Re:- Angmering Manor, Angmering, West Sussex.
Application No. A/3/14

Attached are plans showing amendments to the elevations as requested, they are:-

Re:- Angmering Manor, Angmering, West Sussex.
Your Ref: A/2/14/

Title
ADDITIONAL GARDEN BEDROOMS
ELEVATIONS

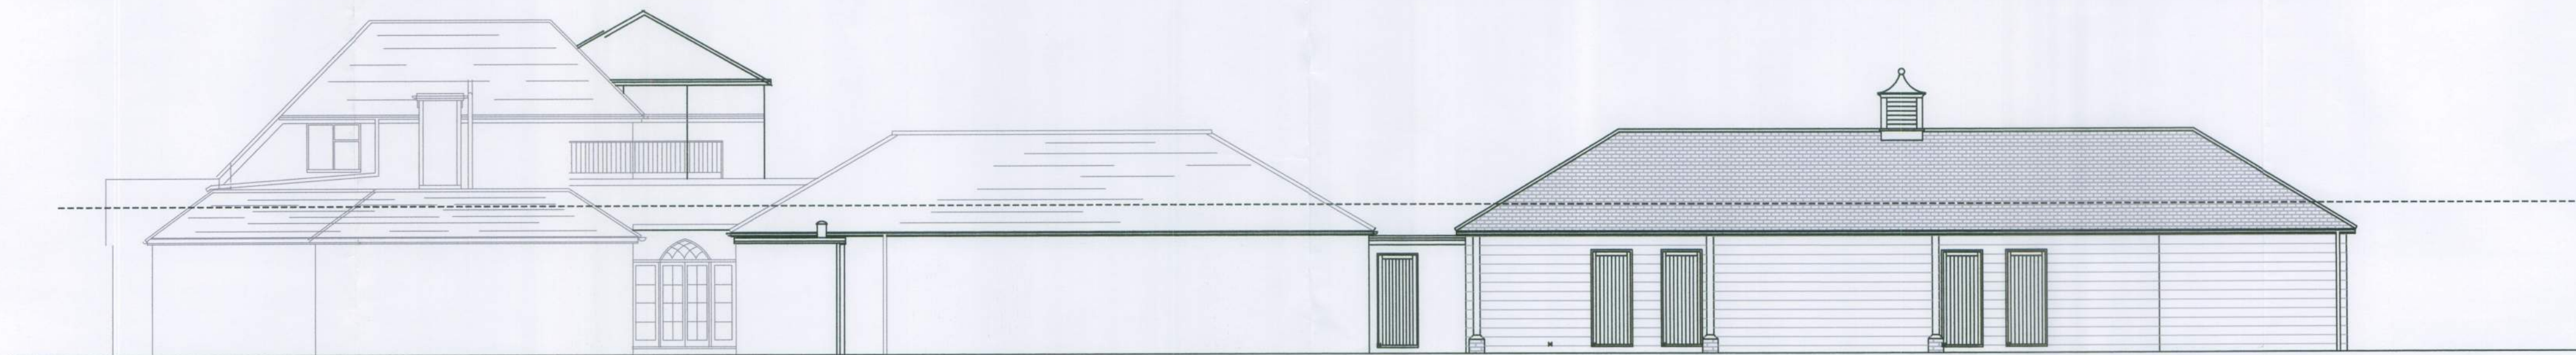
1. Eaves extended to 200mm
2. Full hip roof provided.
3. Georgian arch to windows removed.
Two alternatives are shown:-
 - A. Windows with the arch removed.
 - B. Windows with opening fanlights above.

Fitness Suite
Window shown, inadvertently omitted
from previous plan.

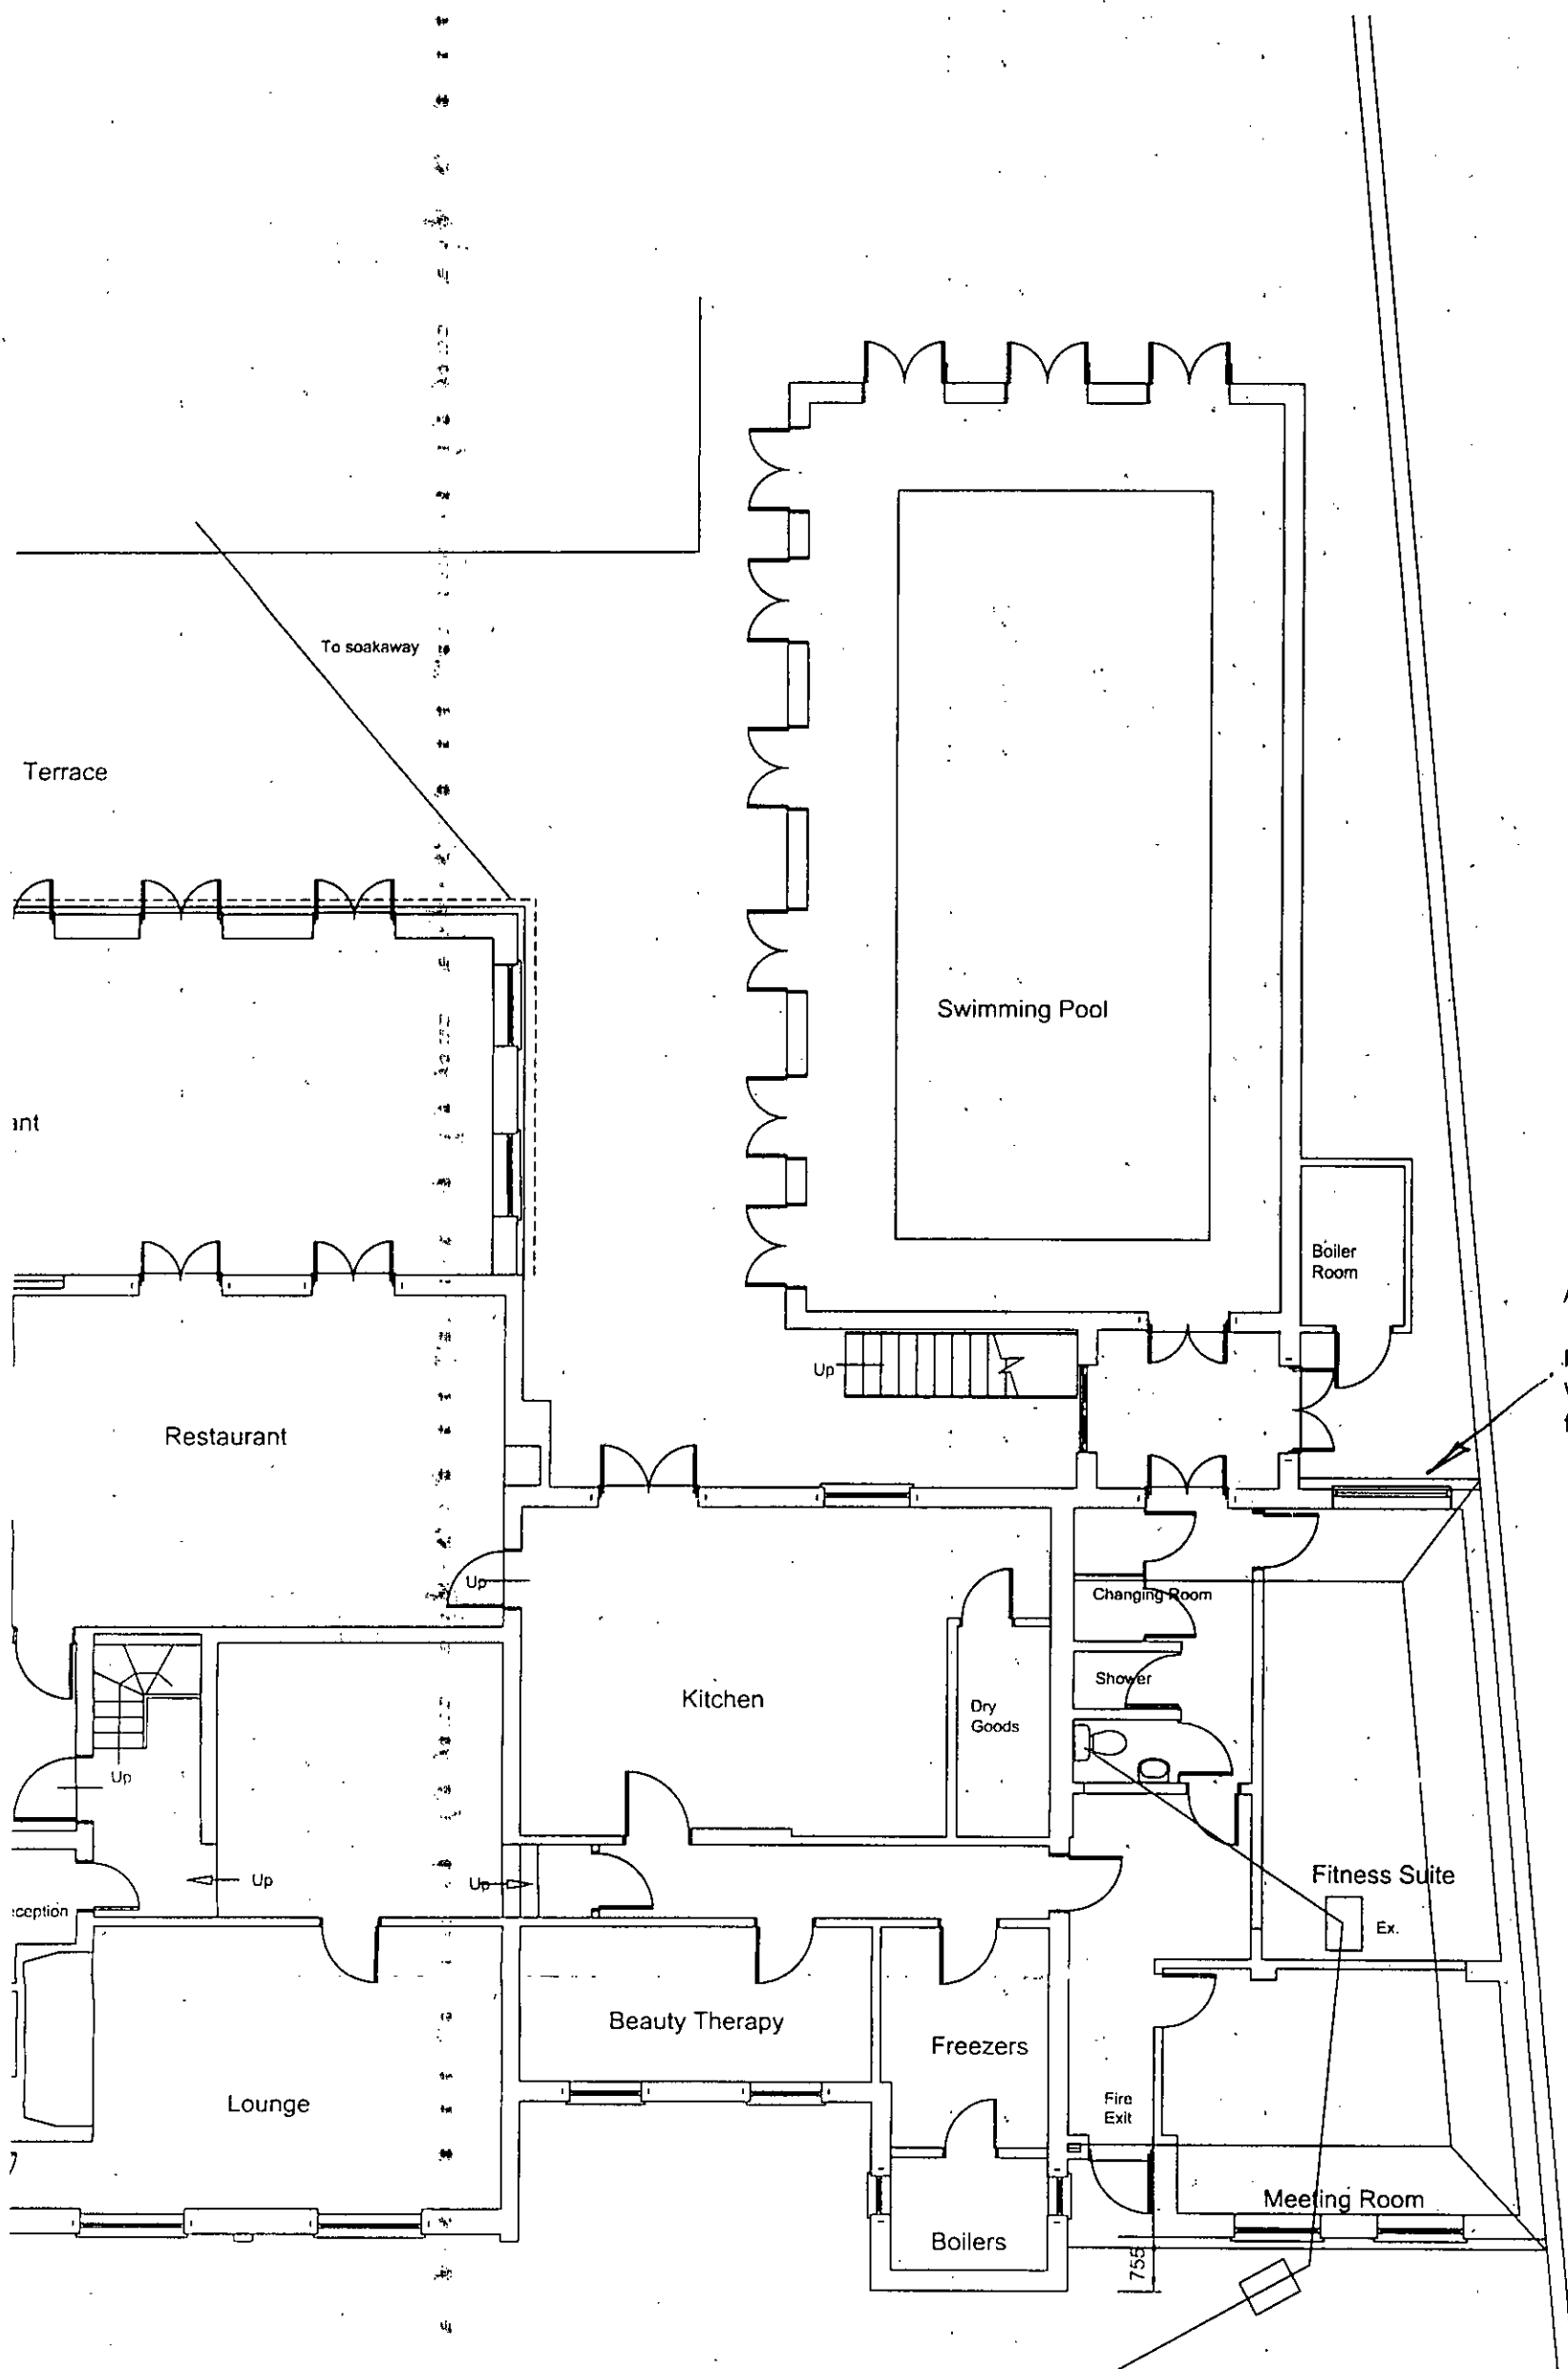
1. Amended block plans, scale 1:500 enclosed
2. One copy of the existing ground floor plan and a copy of the proposed ground plan enclosed showing the window to the Fitness Suite that was inadvertently omitted. A further 4 photocopies of that section of the plan also enclosed. Should you require full copies of the plan please let us know.
3. Validation check list enclosed.
